Your Ref: OWPC17795
Our Ref: LU/67/18/PL 07-03-2018
Please ask for:
Mrs A Gardner

Change of use of part of public highway for external seating area at front comprising of 4 No. tables & 8 No. chairs. This application may affect the setting of a listed building.
14-18 Surrey Street Littlehampton

CLIENT	JD WETHERSPOON PLC		
PROJECT	PUB NO: 534 THE GEORGE INN LITTLEHAMPTON		
DRAWING	PROPOSED PAVEMENT CAFE		
SCALE	A3/1:50	DATE	MAR 2018
PROJECT No	7508	DRAWING No	03
		DRAWN	ALS
		REVISION

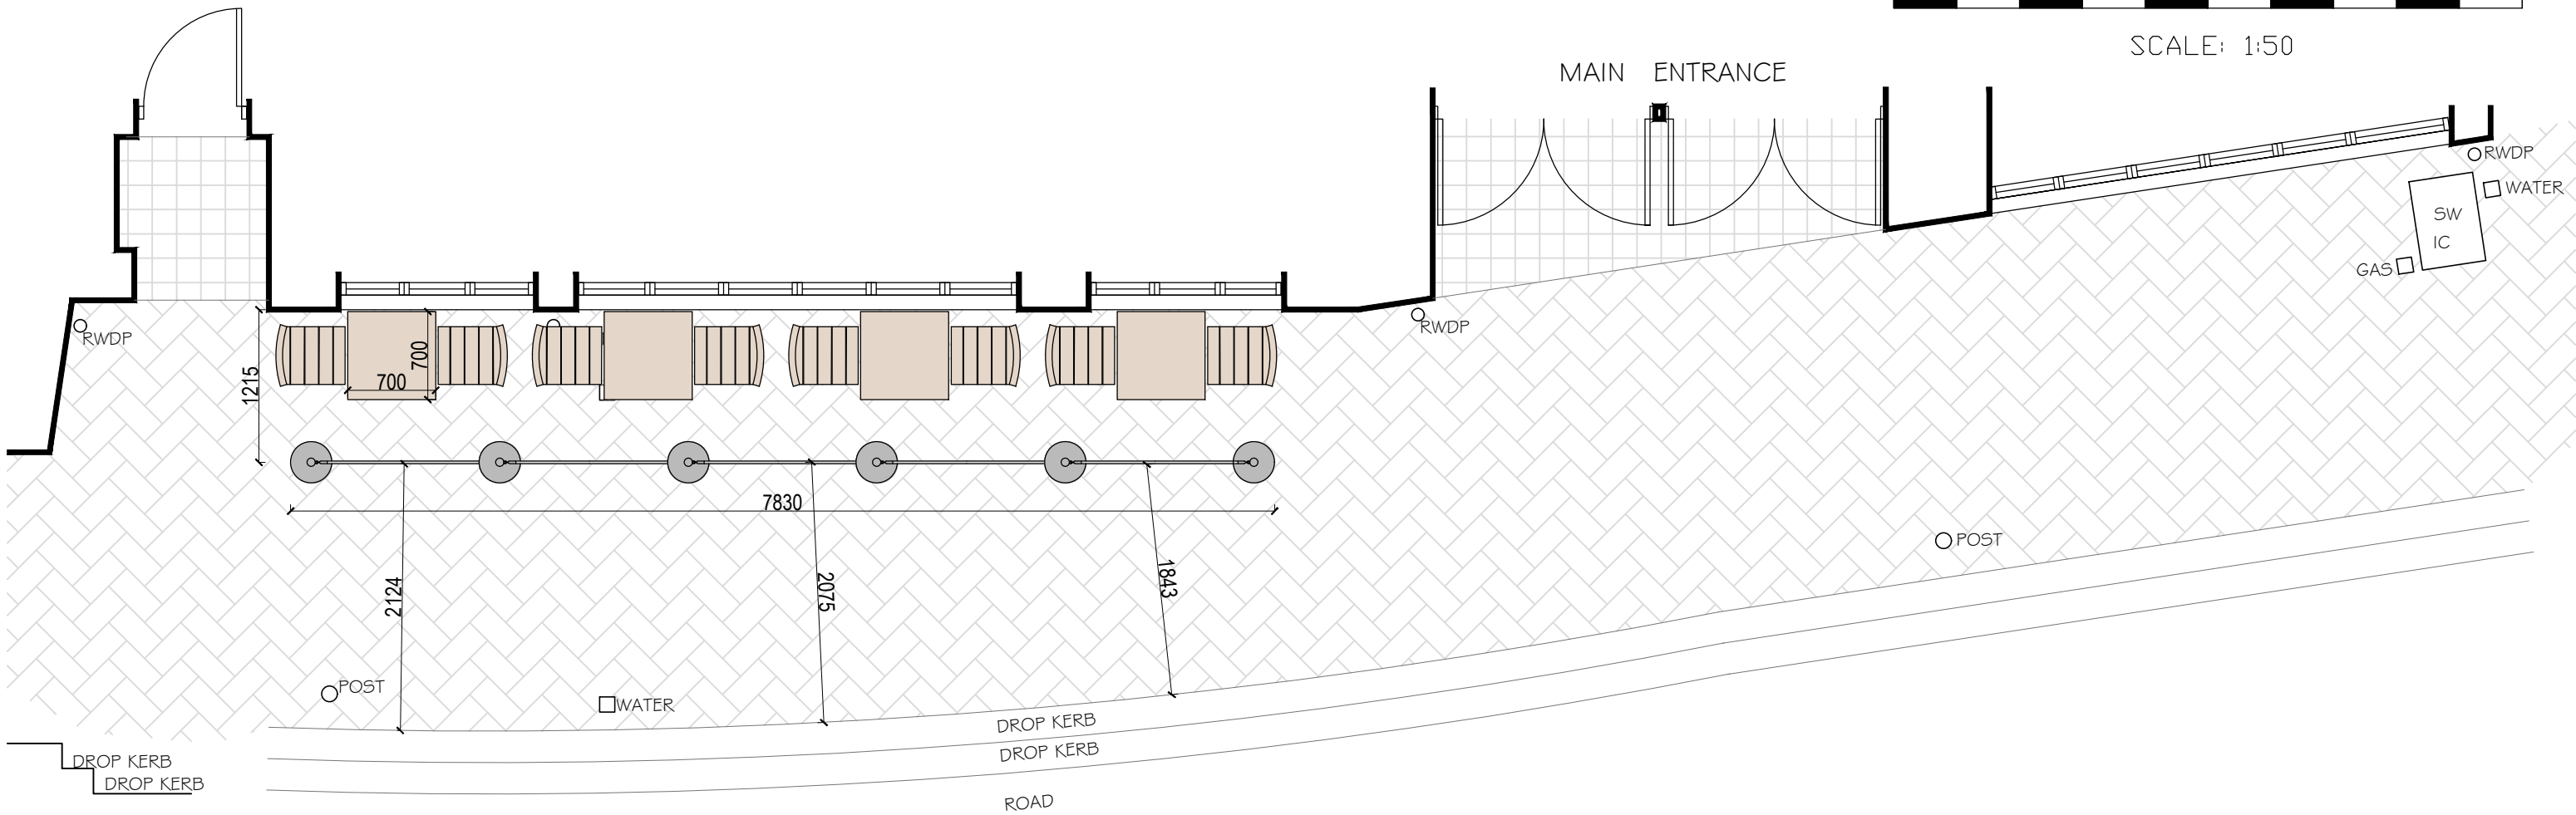
If permitted, it would narrow the available pavement space, adversely affecting the ability of pedestrians, especially wheel chair and mobility scooter users as well as those reliant on mobility aids, to safely and conveniently use the pavement. It was noted that the Highways Authority had yet to comment on the application. Observing that the plans presented with the application did not show the lamppost and highways sign at the front of the premises and the businesses along this stretch of Surrey Street which were also providing chairs and tables outside their premises, it was considered that the proposals would add to the congestion during busy periods and these factors should also be taken into account when assessing the application.
